Our ref ER21465
Your ref 10/09073

Whitehaven Tarrawonga Extension Proposal (MP 11_0047)

Environmental Assessment Test of Adequacy Comments Whitehaven Tarrawonga Coal Project (MP 11_0047)

PLAN
PERMANENT GOONBRI CREEK ALIGNMENT

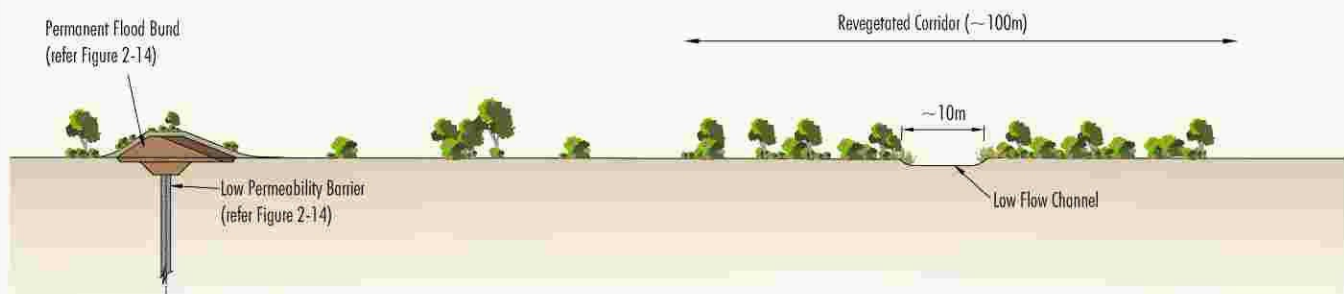
The EA asserts that the diversion of Goonbri Creek will form an effective replication of the current condition of the watercourse. Diversion details are only provided as a conceptual design, which includes two cross sections of the proposed reconstruction of the watercourse. This is not adequate to assess the geomorphic integrity of the proposed reconstruction of Goonbri Creek, nor how necessary variability in channel form, bedload transport and deposition and energy dissipation may be managed.
